Development Control
Ribble Valley Borough Council

Your ref: 22.0176
Our ref: D3.22.0176
Date: 31st March 2022

Address: Lidl, Shawbridge Street, Clitheroe

Proposal: Extension of the existing food store and the provision of nine staff car parking spaces

Drawing No:
AD_110

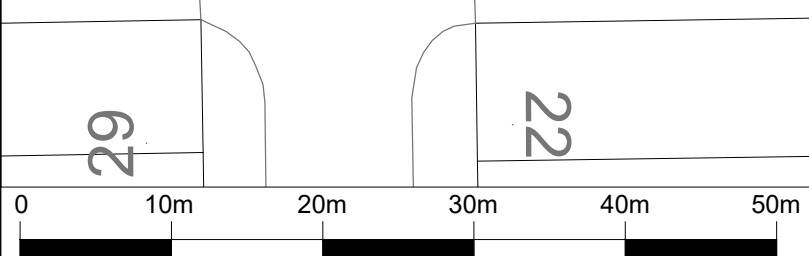
5. The car parking spaces and manoeuvring areas shall be provided as shown on approved Drawing Number AD 110 prior to the extension hereby approved being first brought into use, and the car parking area shall be permanently maintained thereafter clear of any obstruction to its designated purpose
